MEMORANDUM

SUBJECT: SF-22-035 – Sterling Ranch East Filing No. 1
Third Submittal

Engineering Division

DESIGNED BY	MES	SCALE	DATE	08/31/22
DRAWN BY	MES	(H) 1" = 50'	SHEET	6 OF 53
CHECKED BY	(V)	1" = N/A	JOB NO.	1183.30

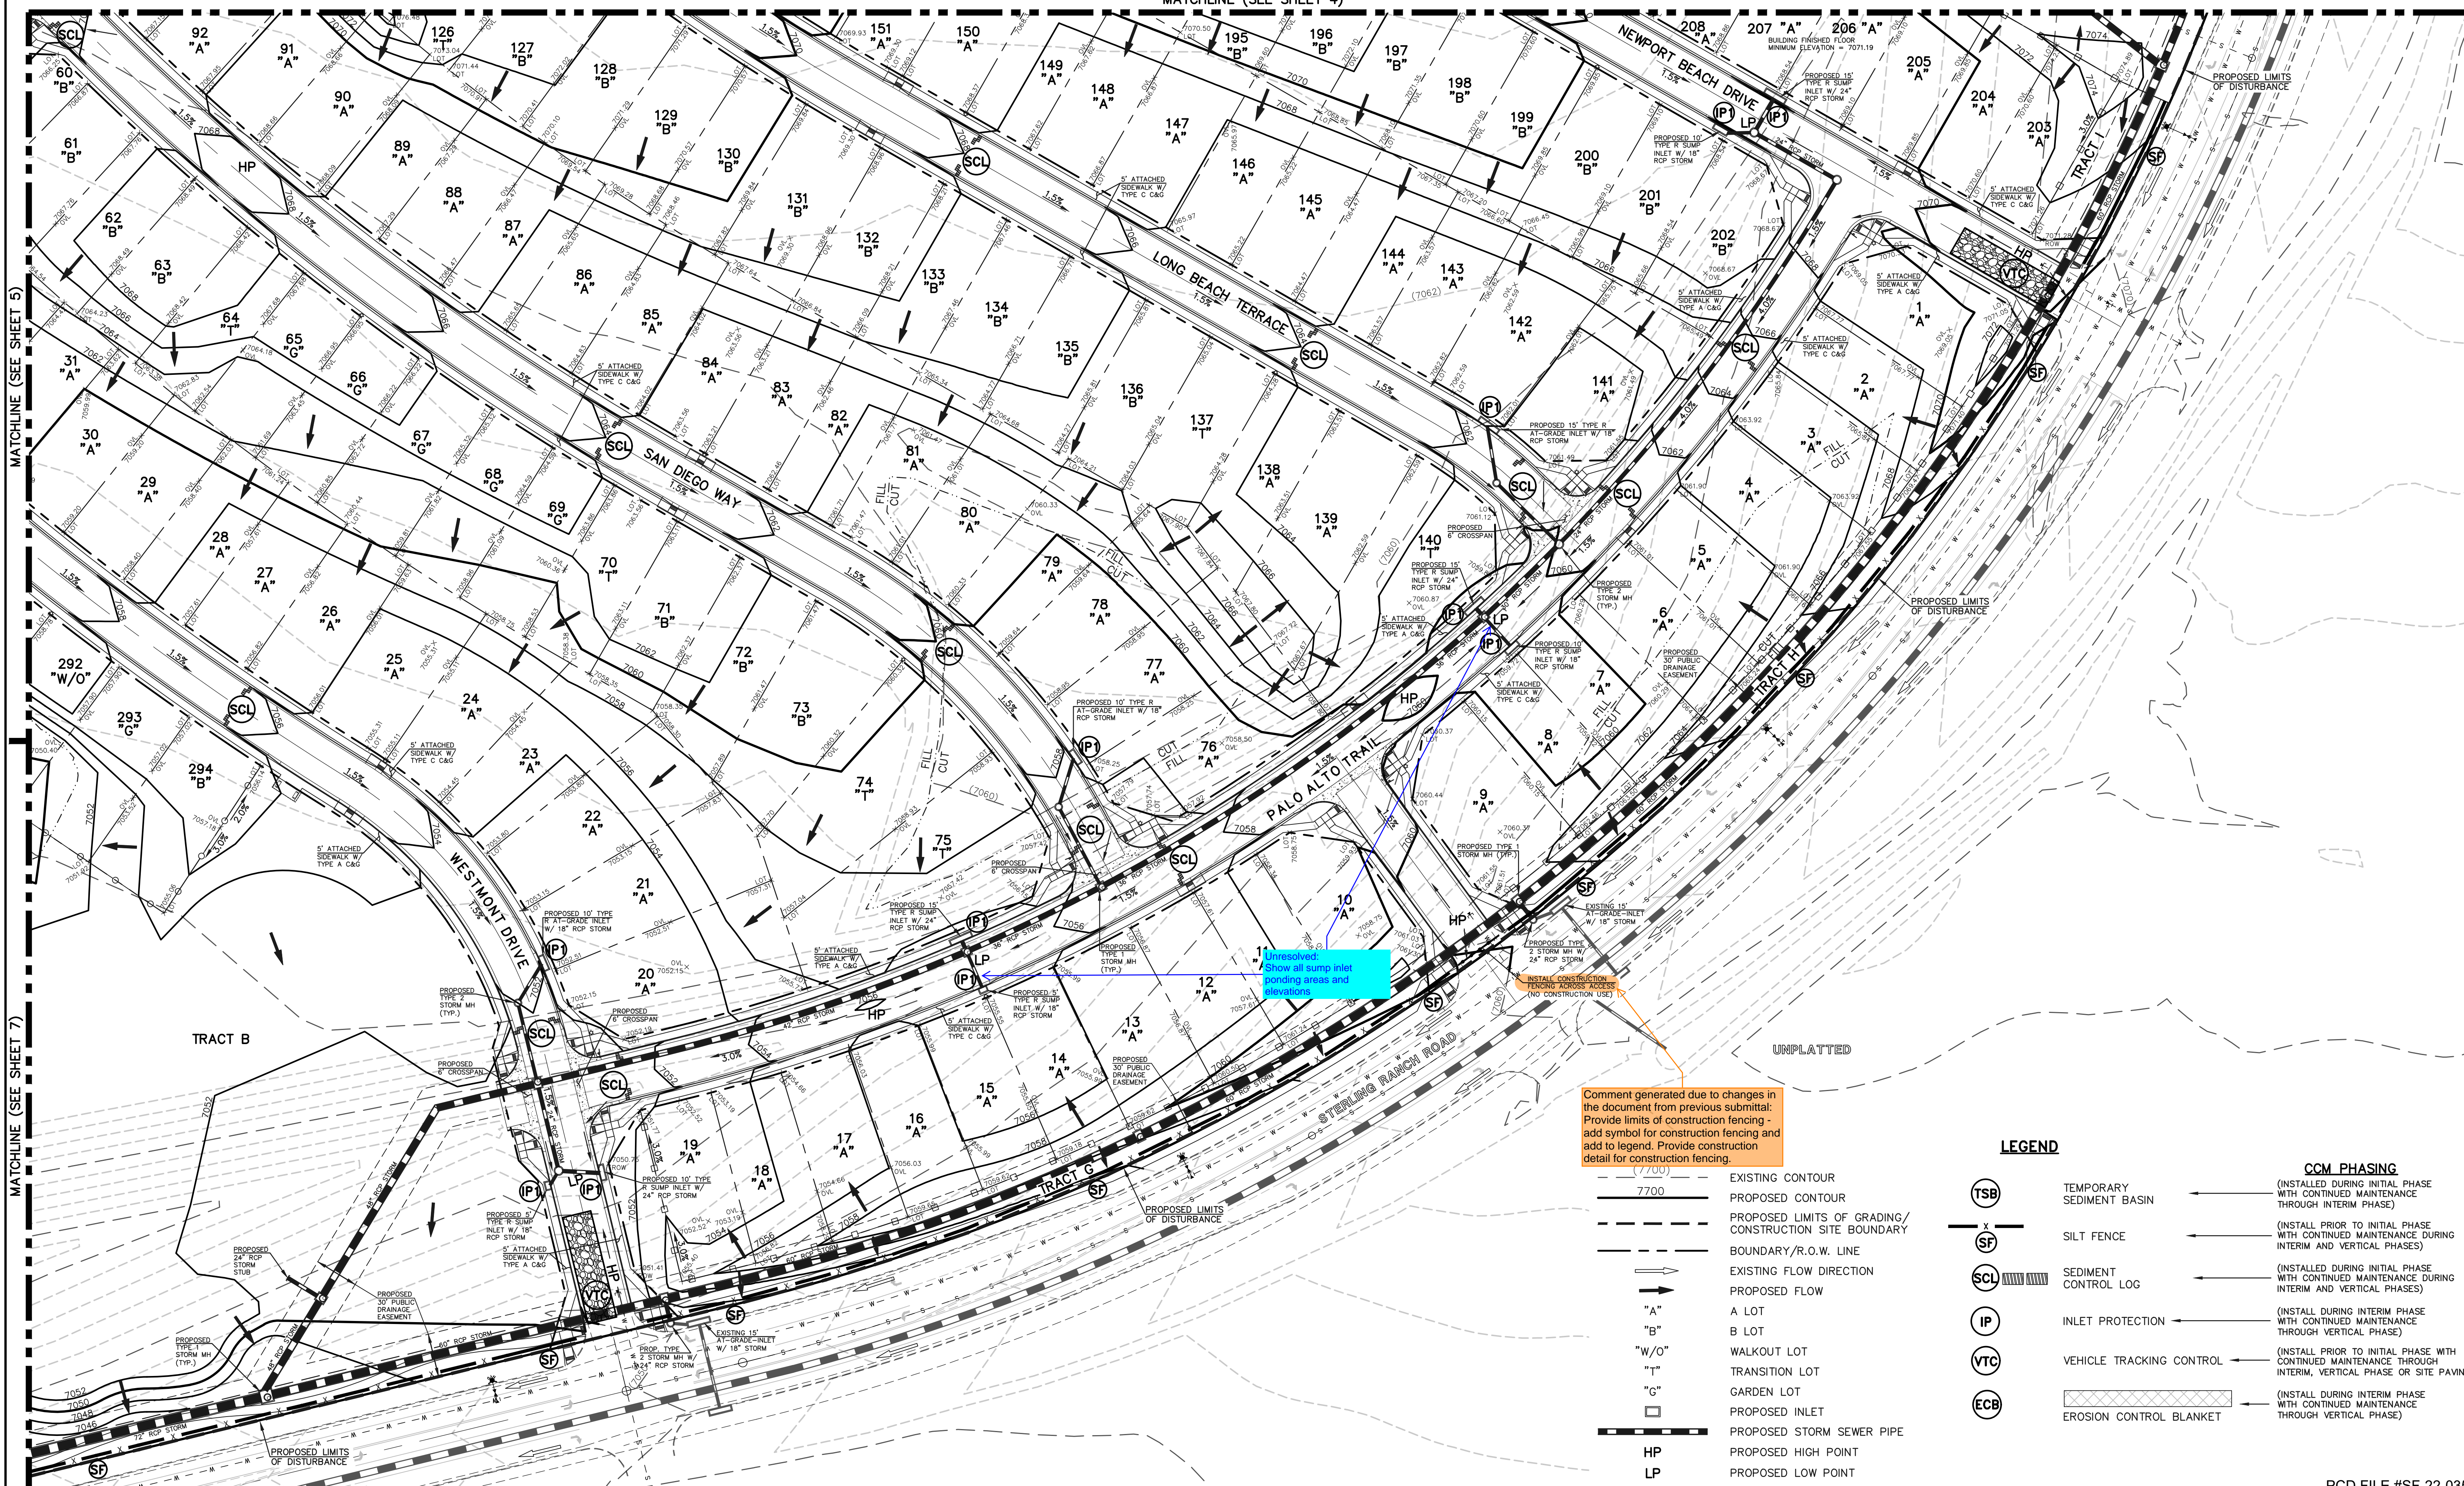
- e. **If groundwater at the north end of Pocatello Trail (TB#22) is only 3.5 feet deep and bedrock is 4 feet deep and cut is approximately 6 feet, address how groundwater will be addressed. Verify that other areas of cut do not have a similar condition. Unresolved** See revised profile/grading.

STERLING RANCH EAST FILING NO. 1 UTILITY SERVICE PLAN			
DESIGNED BY	BB	SCALE	DATE 04/04/23
DRAWN BY	BB	(H) 1" = 50'	SHEET 15 OF 17
CHECKED BY	(V)	1" = N/A	JOB NO. 1183.30

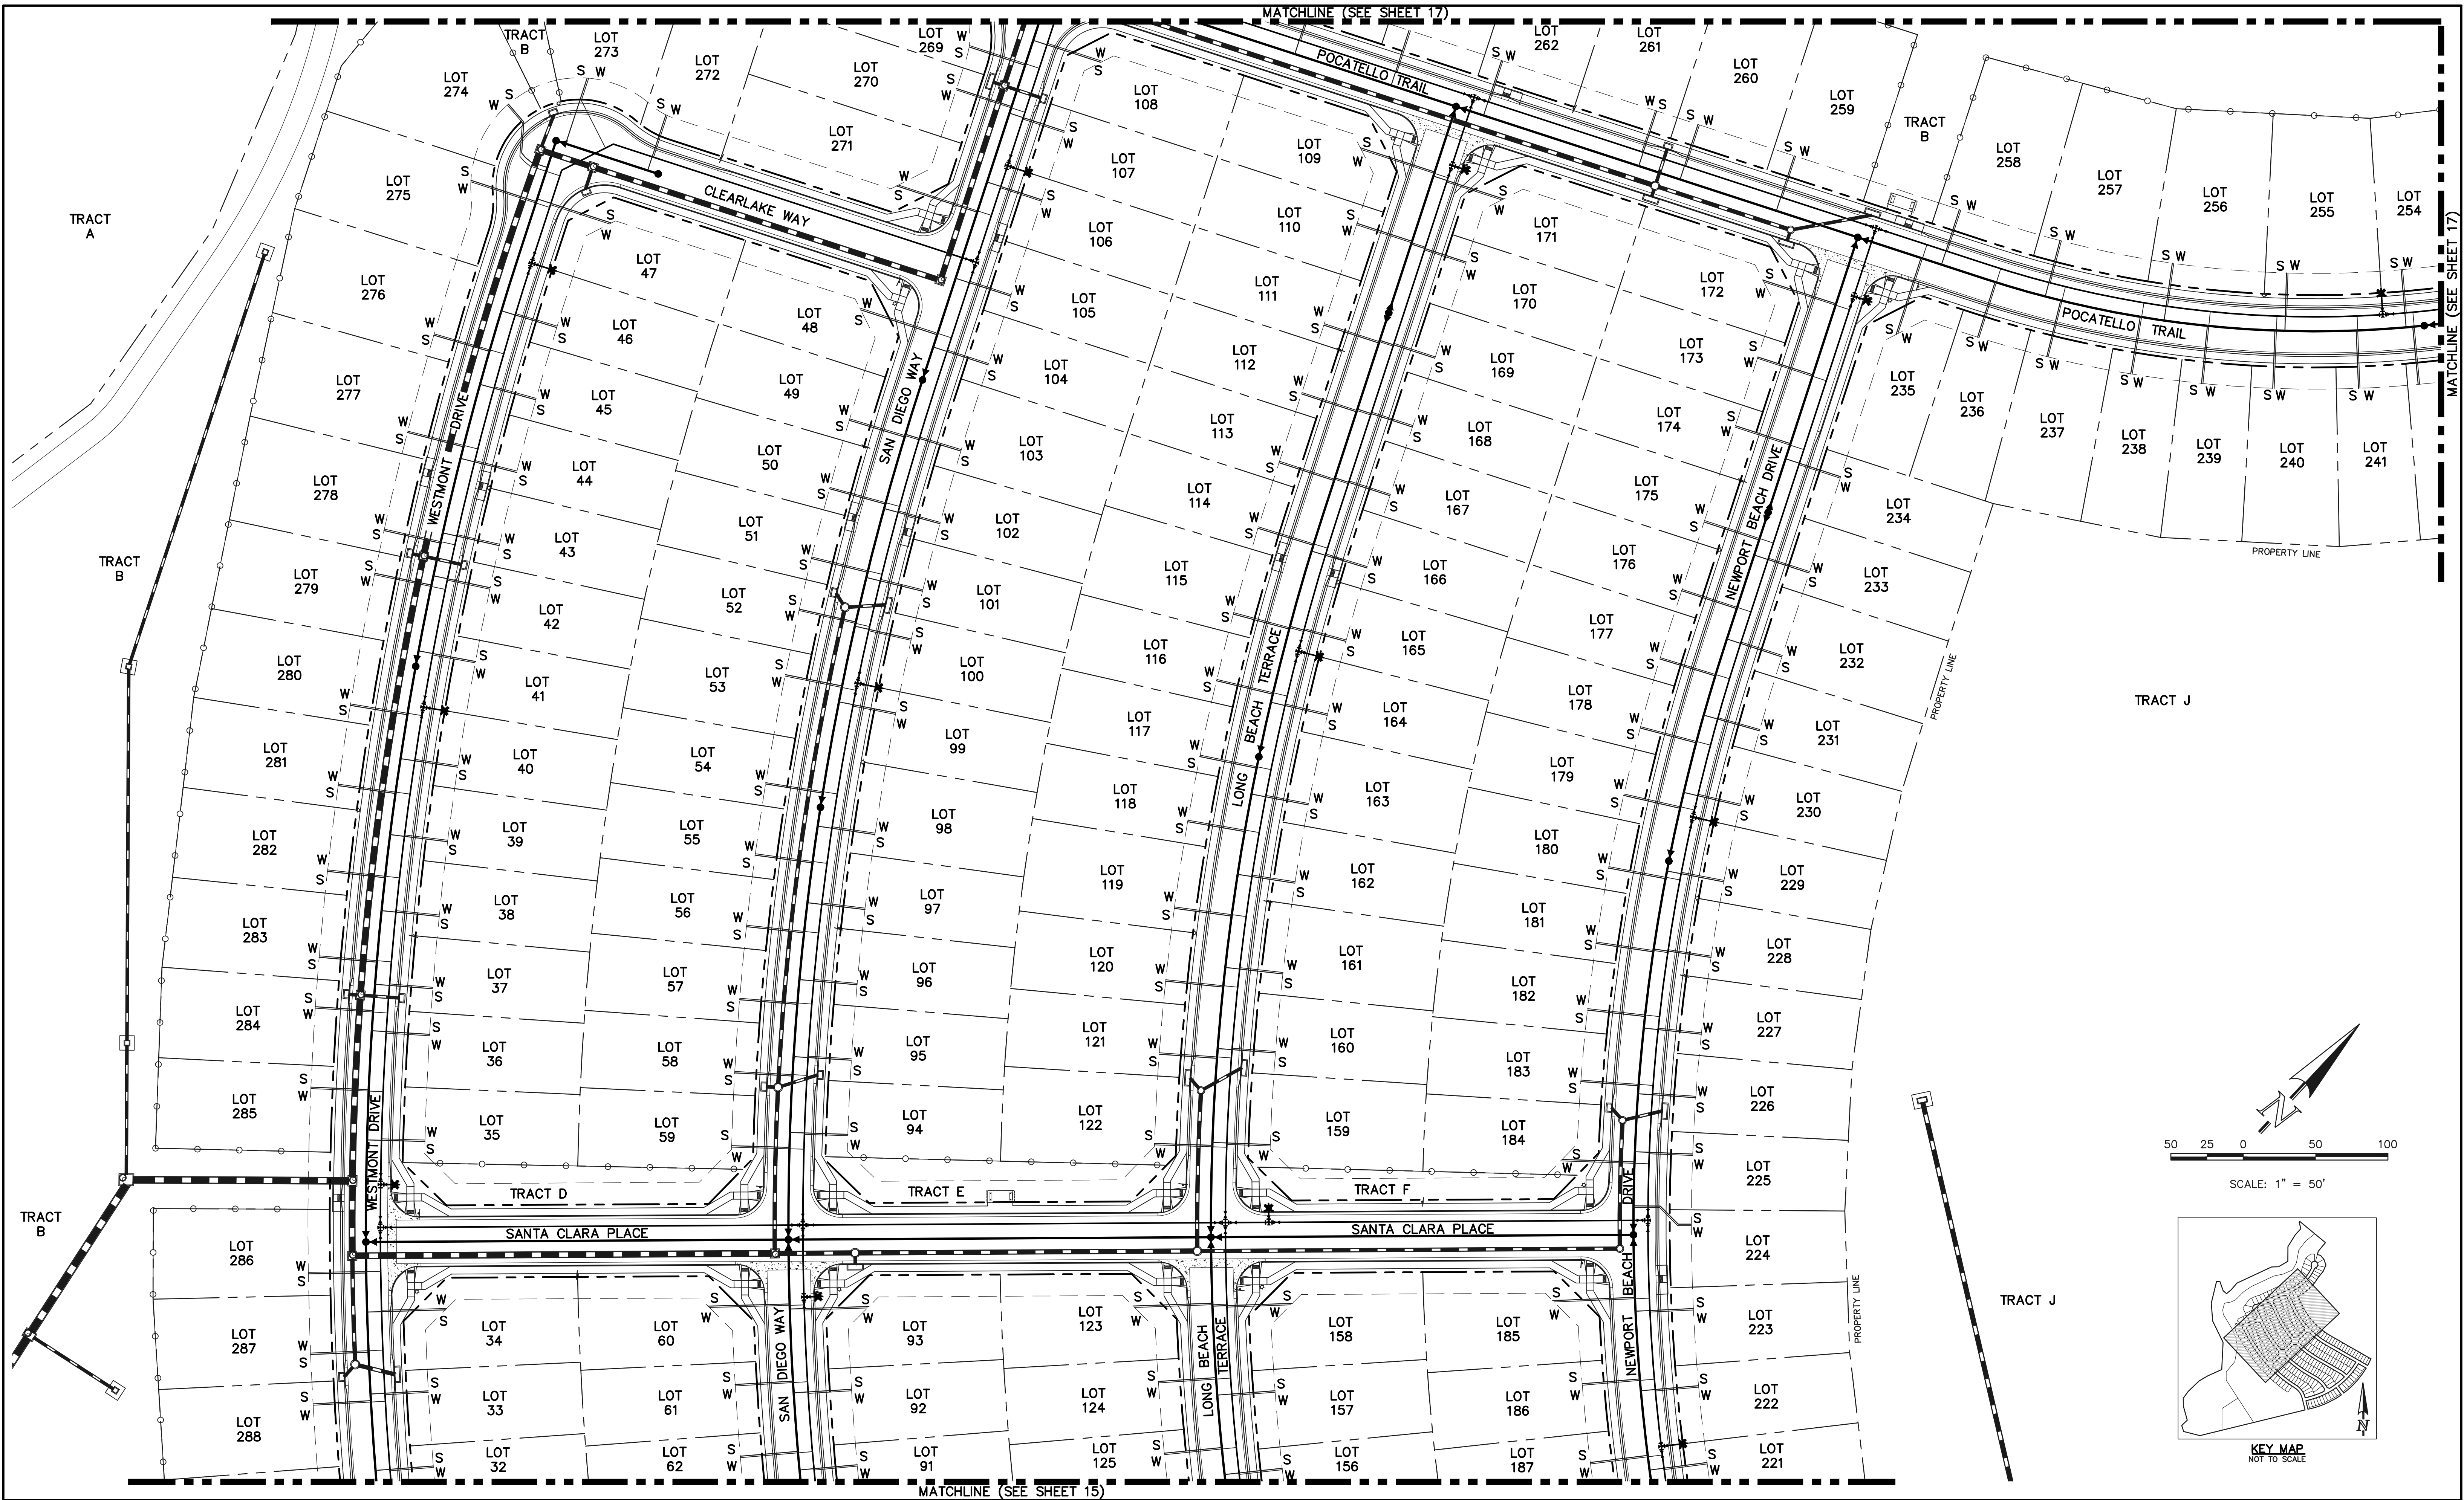
1. See CD/GEC redlines. **Resolved**
2. Provide the County CD signature block on the separate utility plans. Show the underdrain stub locations on the utility service locations details on sheet 17 and note and/or show the underdrain system outfall(s) on Sheet 2. **Unresolved. Signature block added,**
3. Pocatello Trail profile was adjusted on the CD's. Utility plans do not appear to have been updated with revised profile. Please update. **See revised detail**
4. **Resolved.**
5. Provide the additional geotech studies referenced in the Soils and Geology report when available:
 - a. "It is anticipated that the shallow water areas will be mitigated with site grading and the installation of sewer underdrains. **Specific recommendations should be made after additional investigation and site grading has been completed.**"
